**IMMINGHAM EASTERN RO-RO TERMINAL DEVELOPMENT CONSENT ORDER APPLICATION**

**PINS REFERENCE TR030007**

**DFDS' ANSWERS TO THE EXAMINING AUTHORITY'S FIRST WRITTEN QUESTIONS**

IMMINGHAM OUTER HARBOUR  
EBB APPROACH  
NOT TO BE USED FOR NAVIGATION

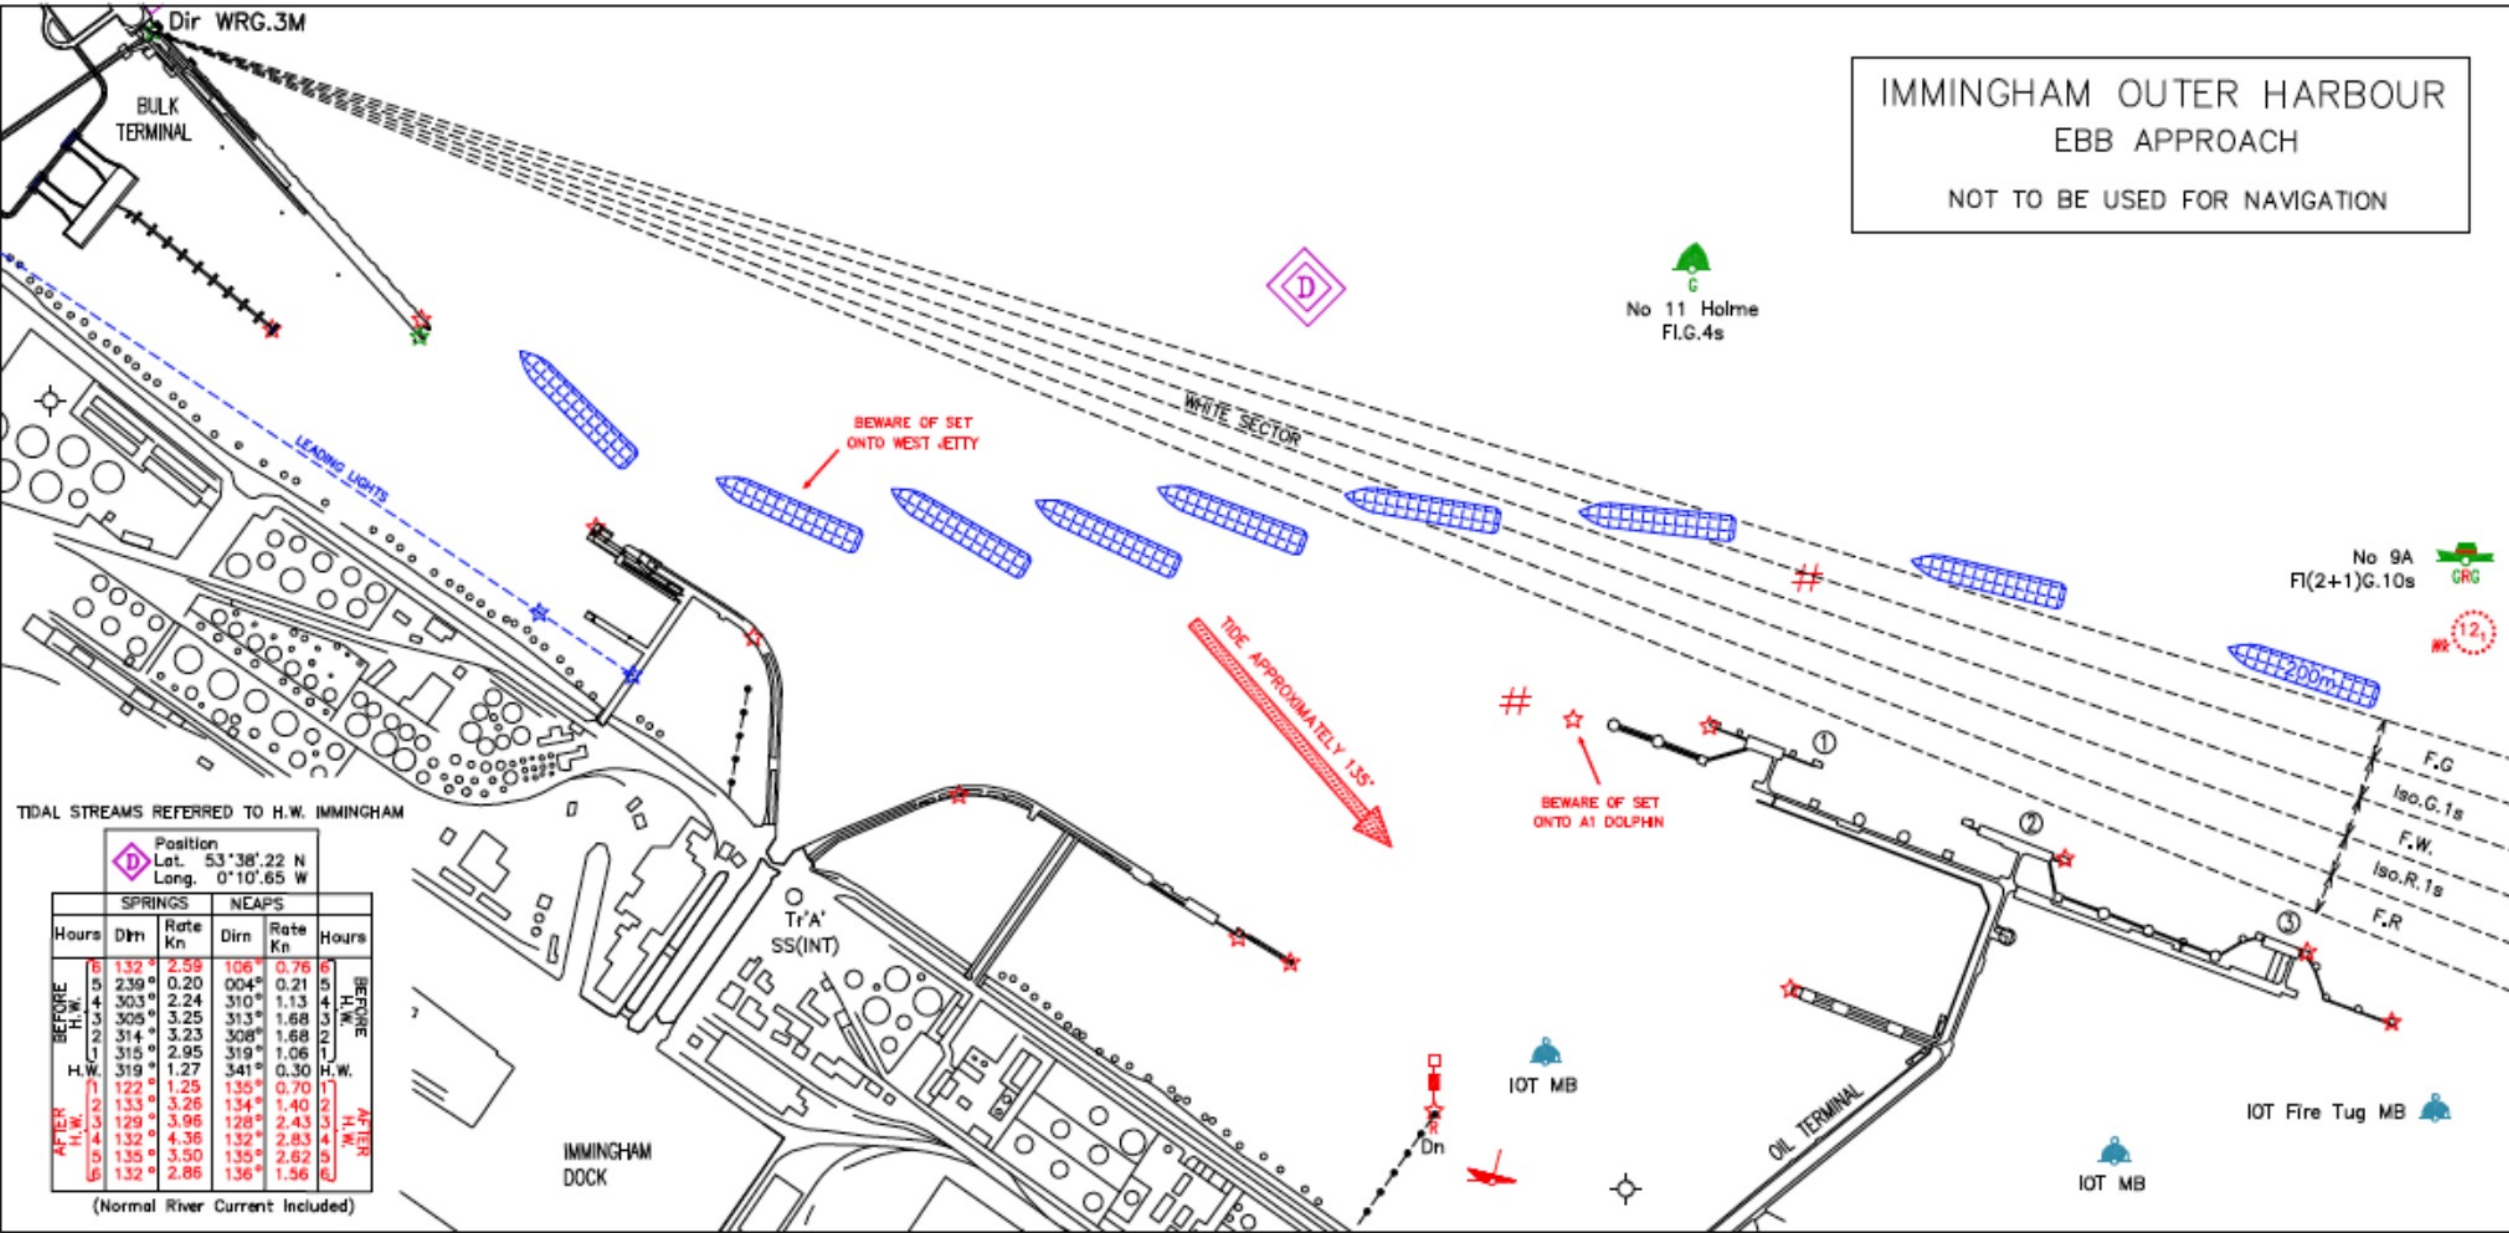
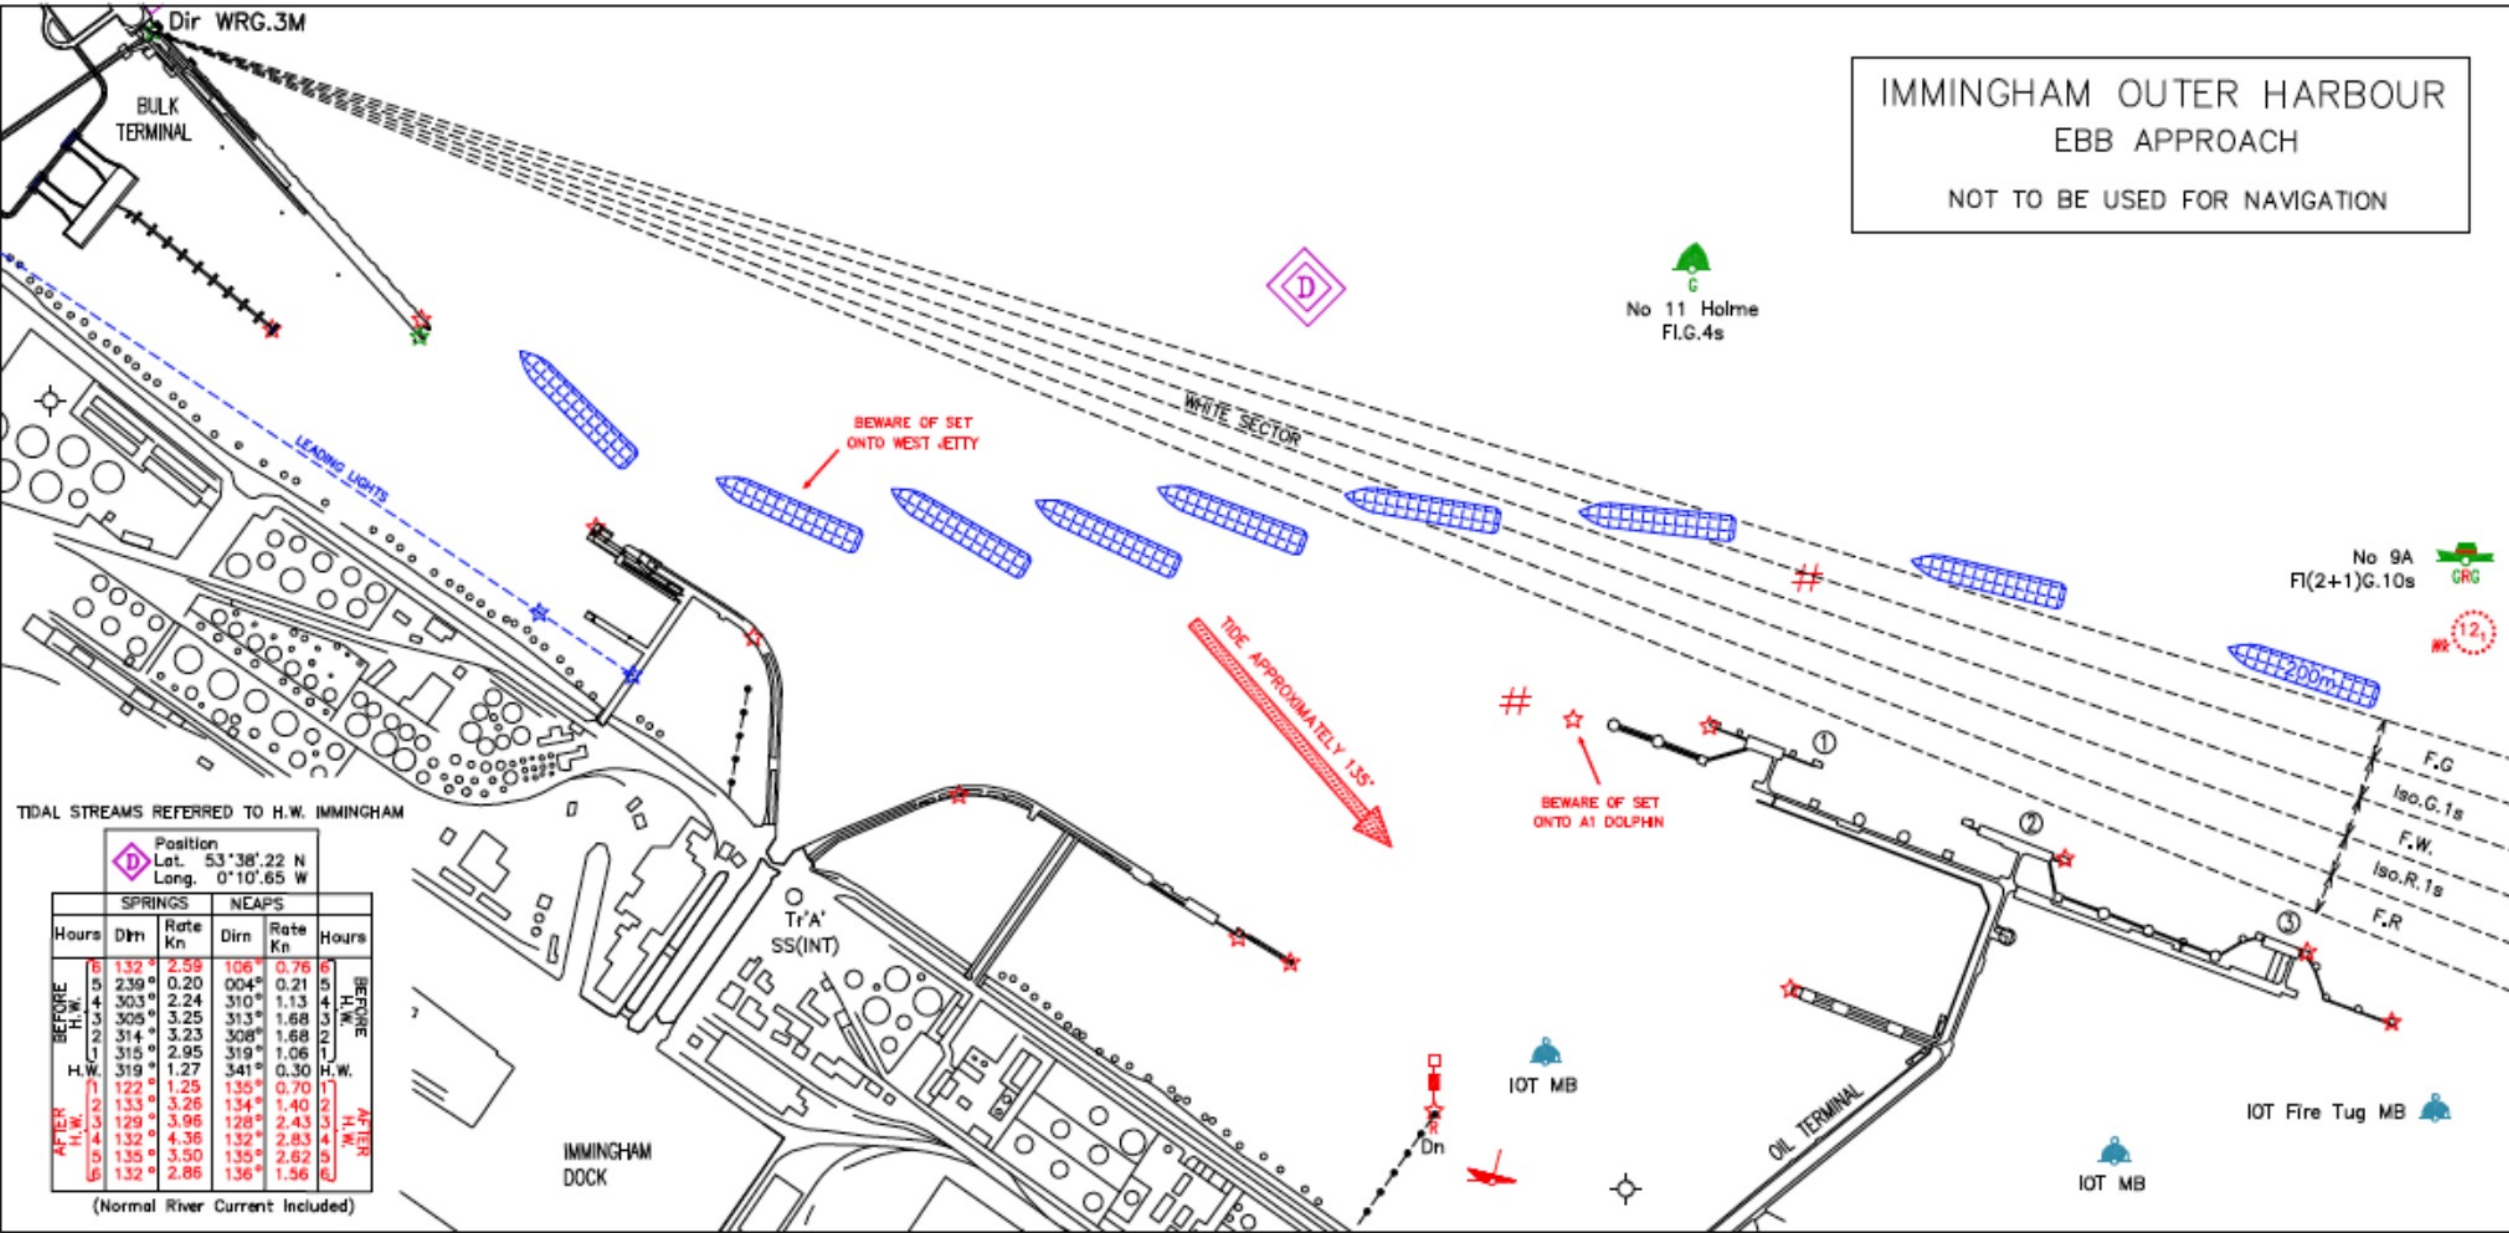
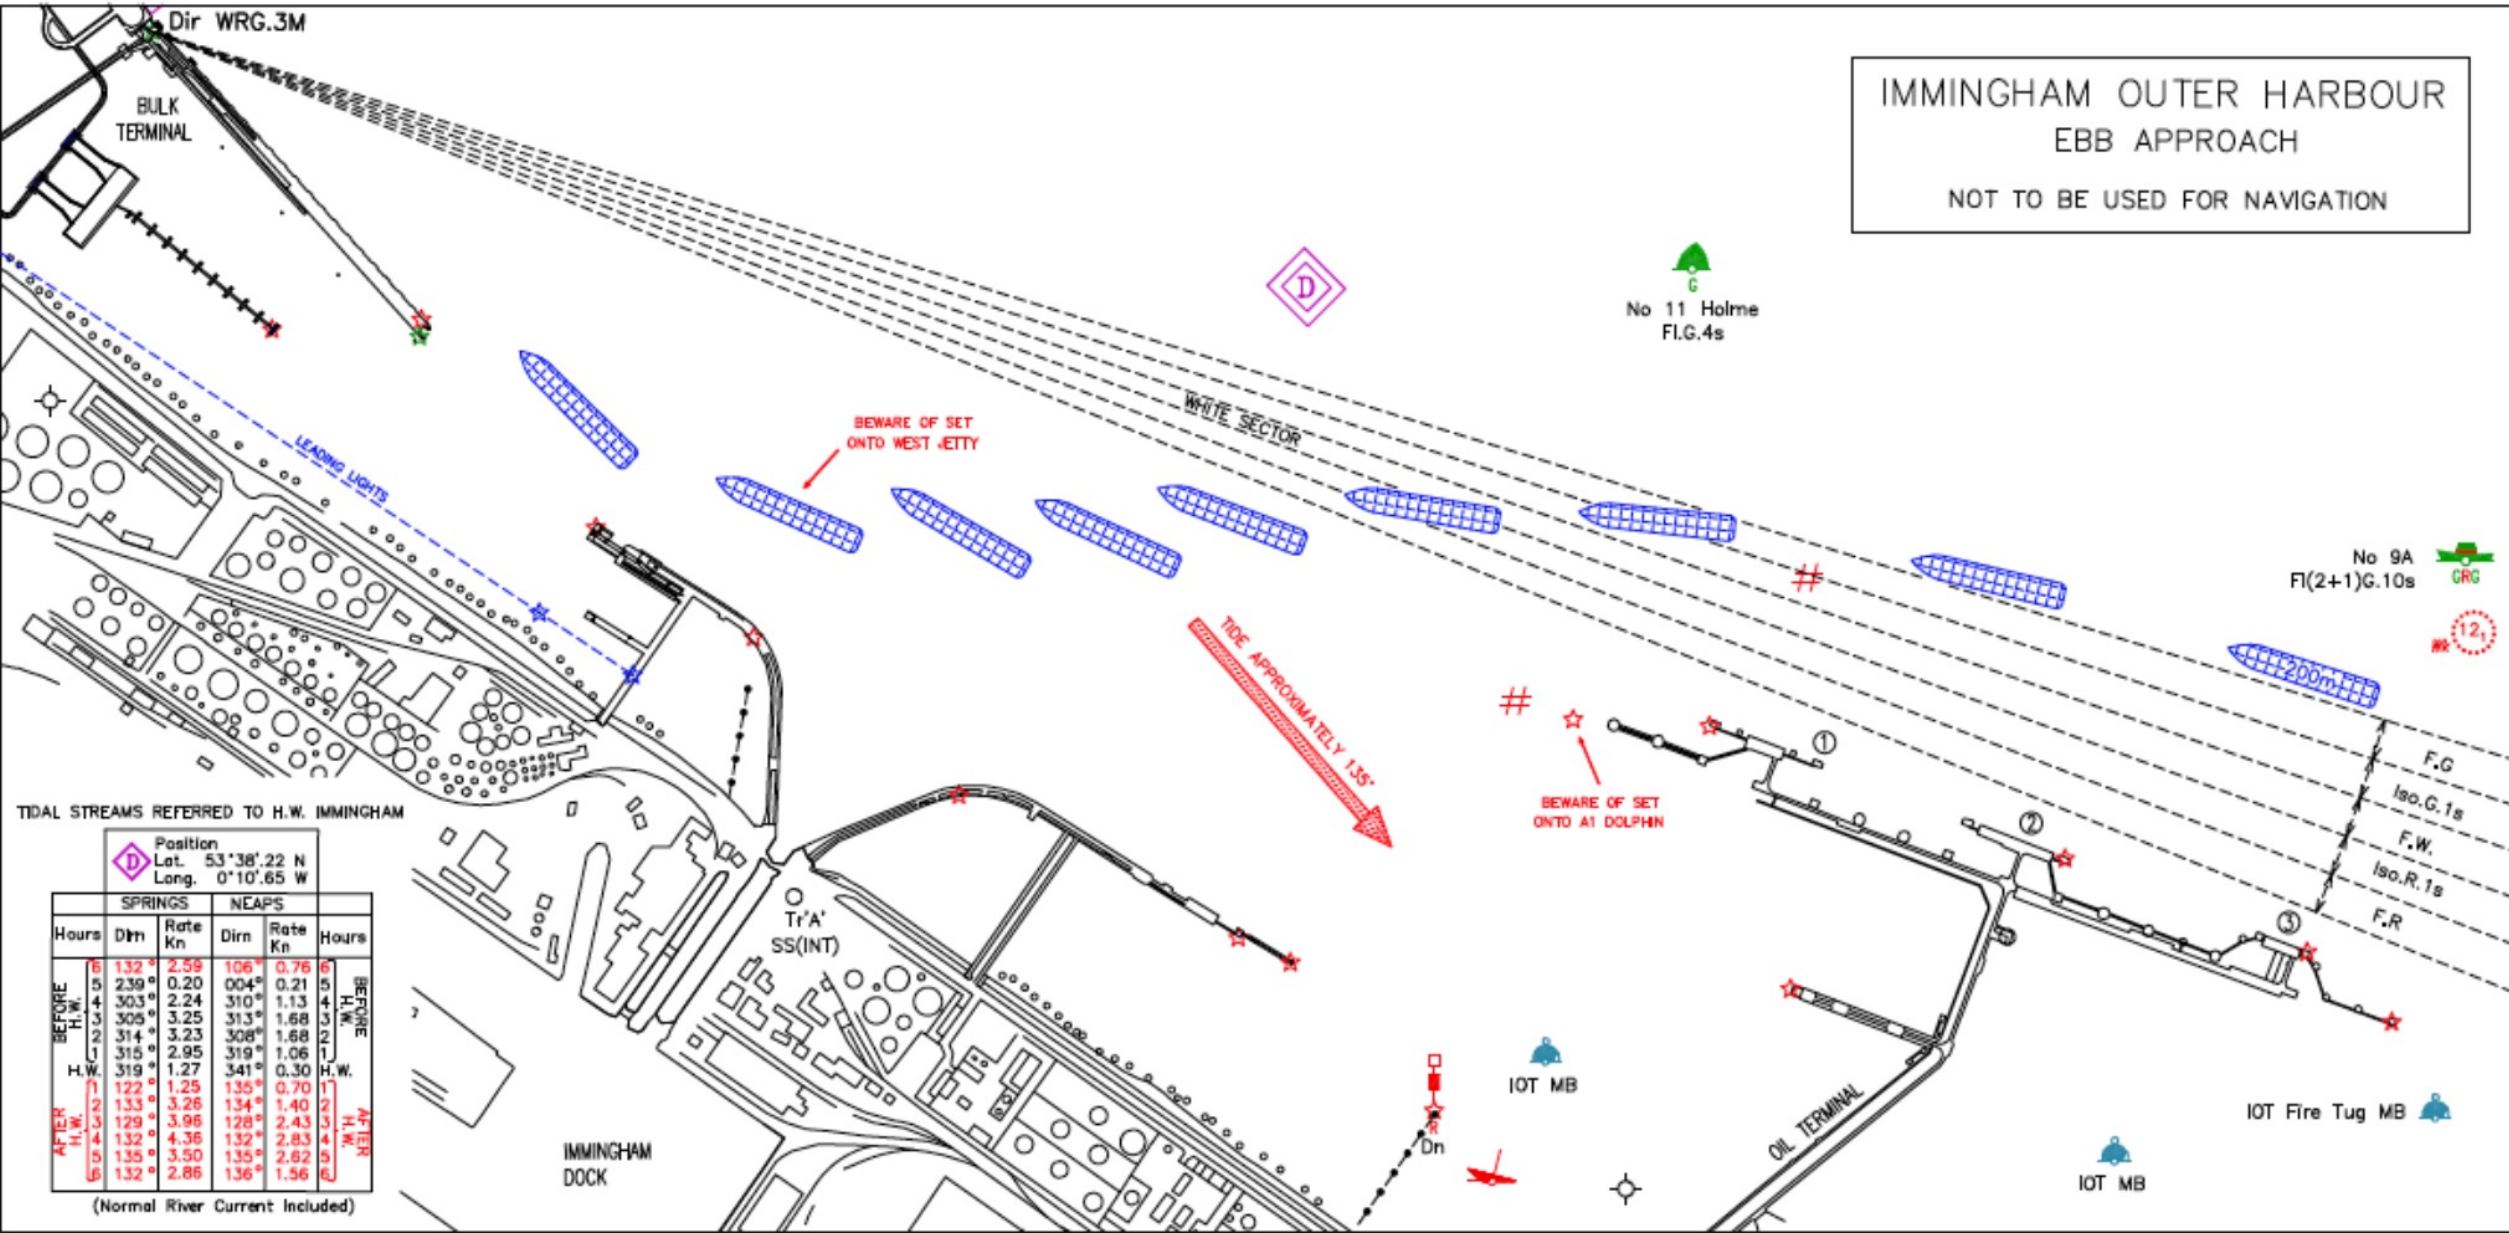
NS.1.21	DFDS	<p><b>Direction of current</b>  Explain the implications of the contention that the current direction north of the Proposed Development is different to that modelled in the navigation simulations presented by the Applicant.</p>	<p>DFDS has had concerns about the tide around the IOT and bellmouth areas for some time and is reflected in our numerous emails and letters in which we spell out our concerns dating back more than 12 months. The daily experience of our masters and the content of numerous publications by the Harbour Authority (and apparently conceded by the Applicant's expert Mr Parr at ISH2) demonstrate that the tide does not, nor ever has, run parallel to the IOT nor parallel to the east and west jetties in the bellmouth area. We cannot, and never would seek to comment about the tidal flow in the vicinity of the proposed development as we, nor any mariner has experience in manoeuvring in this area but the fact that the tide is incorrect around the IOT and bellmouth gives us concerns about the validity of the tide in all areas in the simulated model. Most importantly of all it means the task of manoeuvring around the IOT to get into a position to manoeuvre safely onto the proposed terminal is made significantly easier in the simulations, since if the current is parallel to the berth then it is much easier to dock or leave the berth, but if it is at an angle, even a small one of 20 degrees or so, the manoeuvre is more difficult as the current is pulling the vessel away from the desired path. See also answer to NS.1.23 below.</p>

NS.1.23	DFDS	<p><b>Admiralty Chart data on current direction</b></p> <p>With regard to paragraph 3.23 of DFDS' Relevant Representation [RR-008], submit a copy of the cited Admiralty Chart data and provide a commentary on how the direction of tidal current in the vicinity of the western end of the IOT jetty and pontoons might affect the safety of berthing manoeuvres for the Proposed Development and the IOT's berths. (If not already fully answered in written submission following ISH2)</p>	<p>DFDS ordered the Admiralty Chart and it has just been received. It is of A0 size and so difficult to scan or photograph. It will be sent to the case team by post and should arrive by Deadline 3.</p> <p>As will be able to be seen from the chart and the appended ABP Humber Estuary Services published document (see <b>Appendix 1</b> of this document) the tide runs at an angle to the line of the IOT. The IOT berth is oriented at 292°/112° whereas the tide runs at 315°/135°; the effect of this is that vessels are pushed strongly off the berth on a flood tide and strongly onto the berth on an ebb tide. The ebb tide is stronger than the flood tide due to the fact that the Humber Estuary drains over 25% of Great Britain's fresh water.</p> <p>The effect of this is that in the simulations carried out by Applicant the vessels commence their manoeuvre north of the IOT and need to navigate around the end of the berth and into a good position prior to commencing their 'reverse parking' manoeuvre. As the tide in the simulations is, by admission of their own simulation consultants at the hearing, wrong in the area north of the IOT the simulations fail to recreate the complexity of achieving the first manoeuvre. In doing so they give an unduly favourable impression of the complexity of the manoeuvre and the challenges that vessels will face in safely navigating to and from the proposed development.</p>
